**Consultation Response from KC,
 Trees**
2025/90657 54, Victoria Street, Clayton West, Huddersfield, HD8 9NW
Erection of three dwellings
Date Responded: 24/04/2025
Responding Officer: H Irving
Responding Ref: 03/08

### Tree Constraints Plan

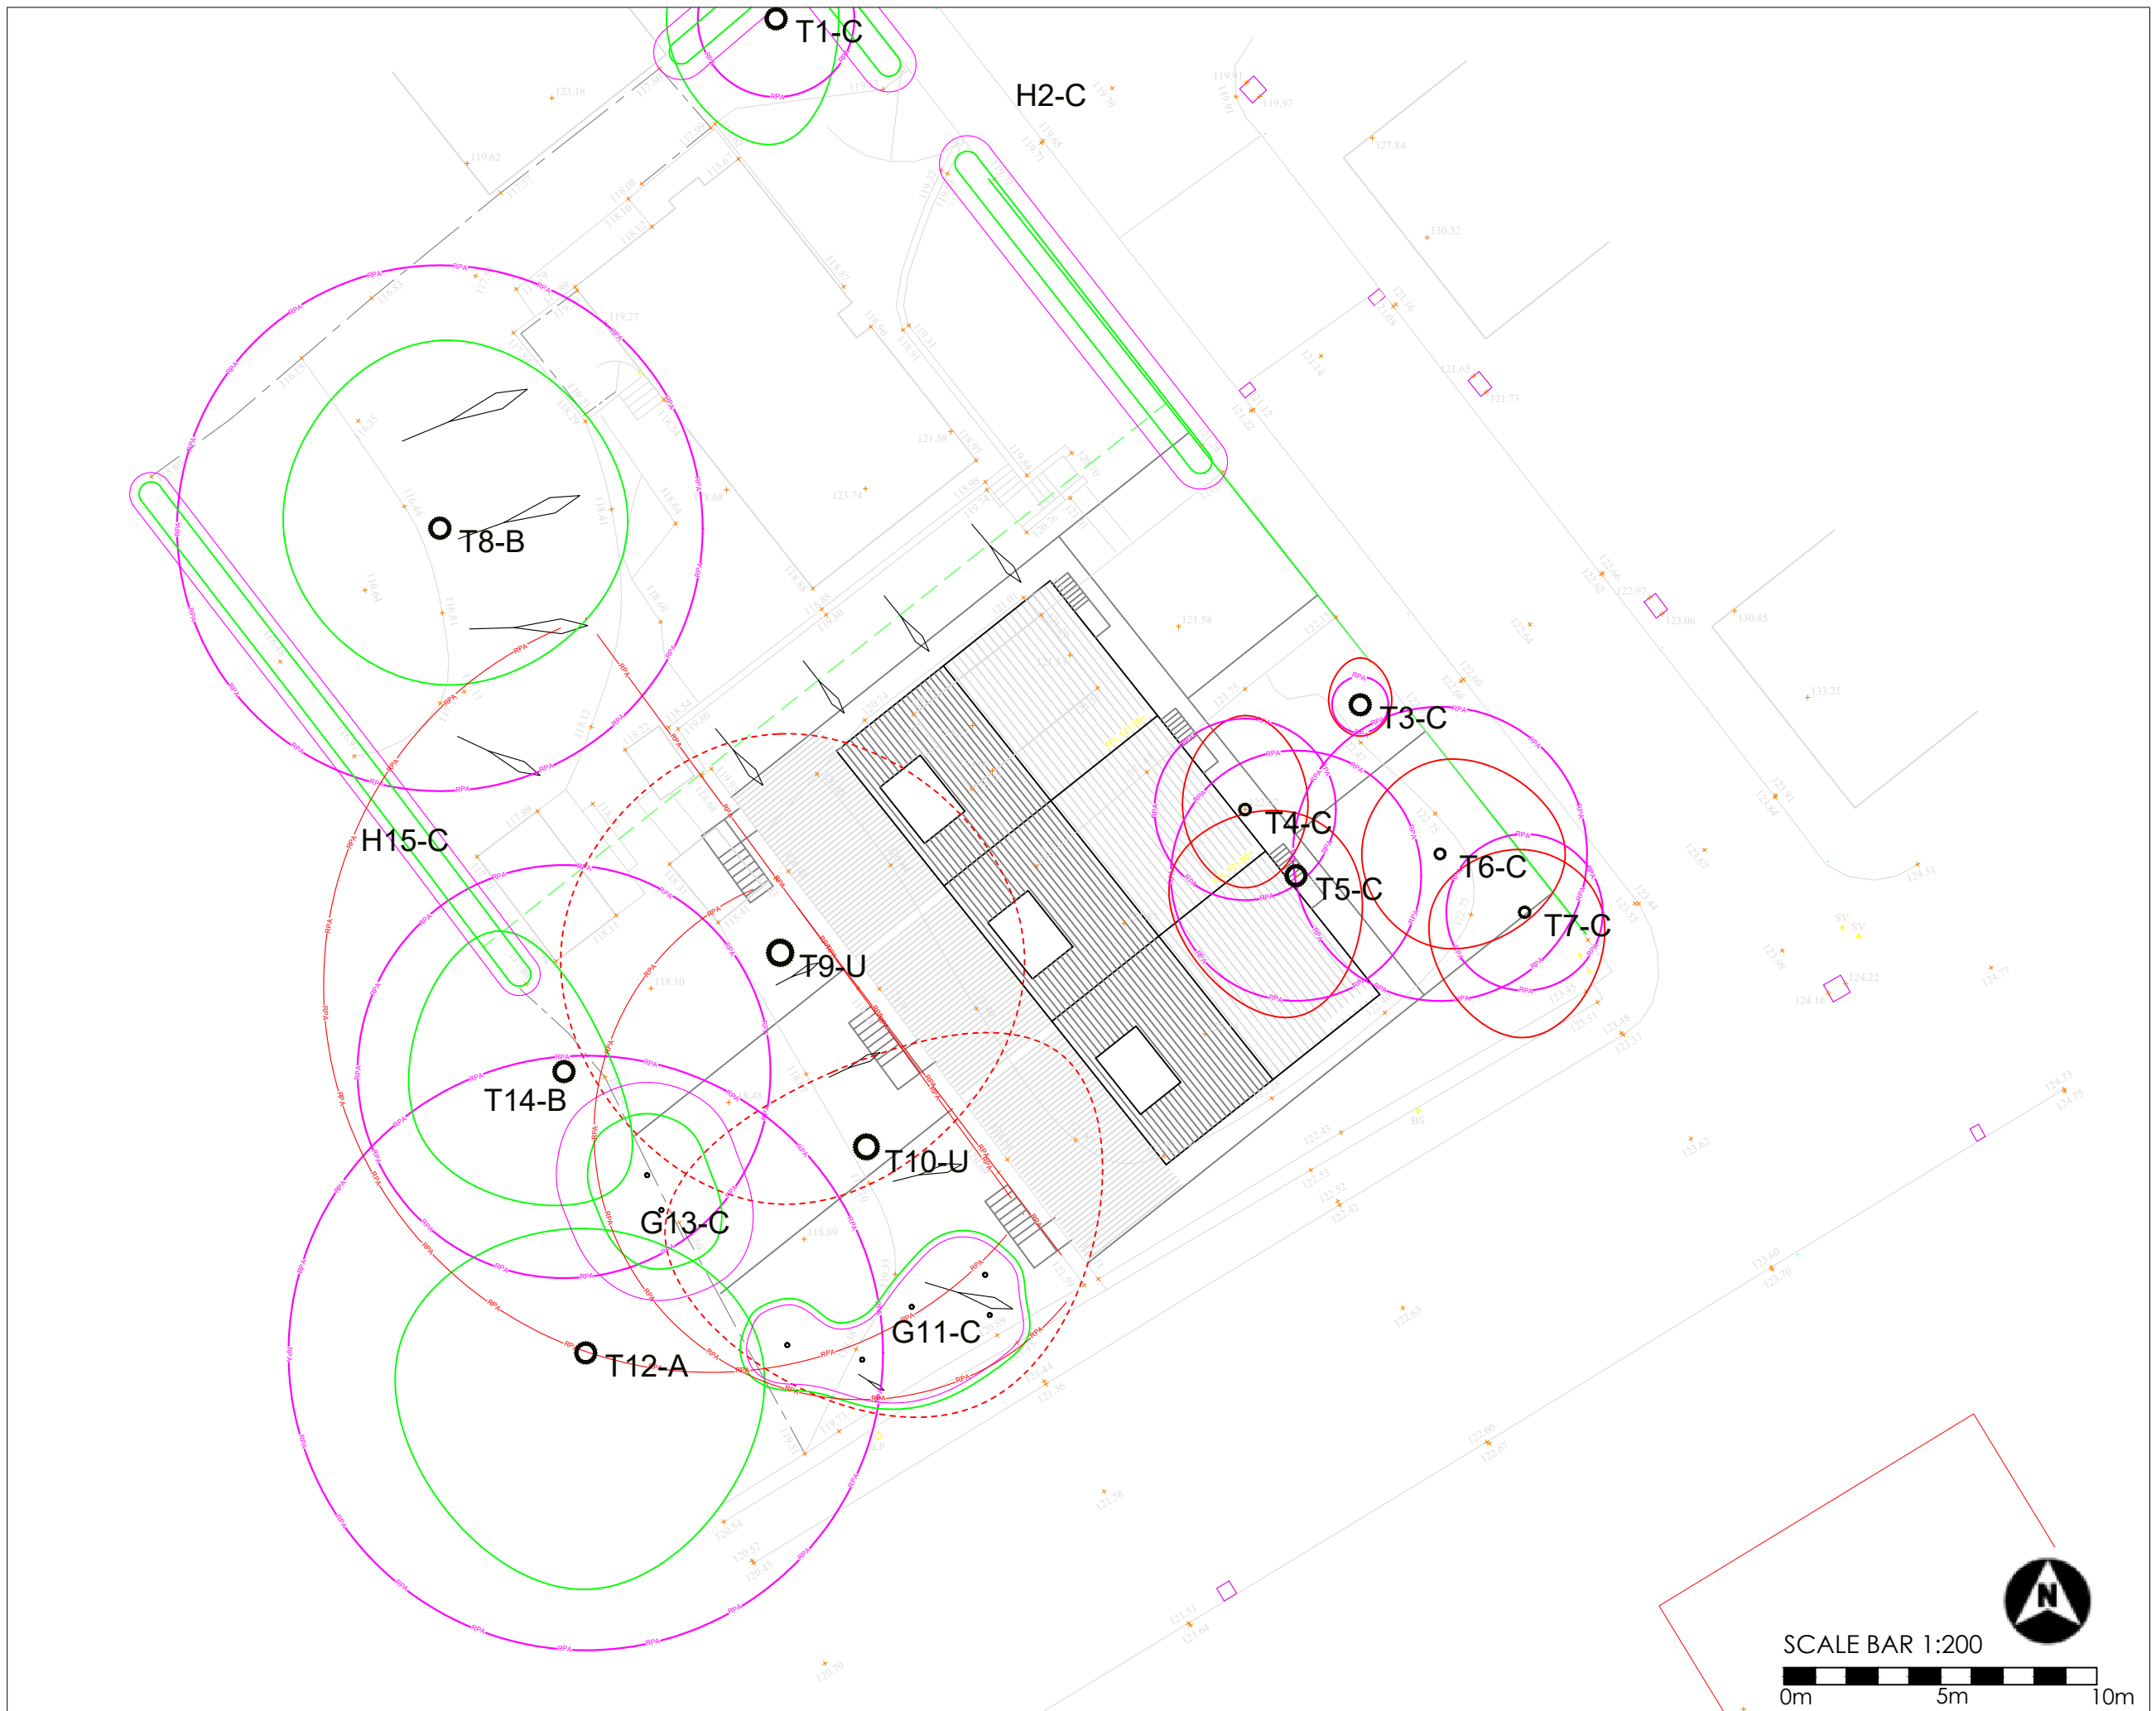
The sycamores are protected by TPOs 03/08/t69 and 03/08/t68 and are identified within the AIA as T9 and T10 respectively. Both mature trees are large and offer significant amenity value and environmental benefits to the local area. However, T9 and T10 are recorded as BS5837:2012 Category U and as such are recommended for removal due to the presence of the fungal tree pathogen honey fungus *Armillaria mellea*.

Following a site visit, and considering the evidence provided by Tree Care Consultancy it would be acceptable for all seven trees to be removed (subject to replanting), if development proposals were consented. However, the two protected sycamores would have to be replaced by a tree species which could reach a similar size, as a Condition of their removal. These replacement trees would then be legally protected under the previous TPOs*.

To comply with S.206 of the Town and Country Planning Act 1990 and Kirklees Local Plan Policy 33 and 24 (i), the replacement TPO trees must be allowed the space they require to mature in this location, so that they can eventually take up the space of the existing large, sycamores. This is to ensure the future amenity of the local area, which the TPO was made to protect. The current TPO sycamores have formed wide canopies, which spread across most of the West of the site. Therefore, proposals that encroach too far into the existing tree canopies cannot be supported from an arboricultural perspective.

The main point of objection is that there would be significant pressure to remove or prune the replacement TPO trees, from the future residents, who would foreseeably object to tree canopies overhanging and shading most (and eventually all) of their rear garden.

* Ordinarily replacement planting should replace like-for-like, but in this circumstance, Oak (*Quercus* sp.) would be selected because it is a native tree species, which is less susceptible to *A. mellea* than sycamore due to its thick bark and tannins. This species has the potential to grow to a similar, large stature as the sycamores they would seek to replace, should they be removed following a successful planning application.
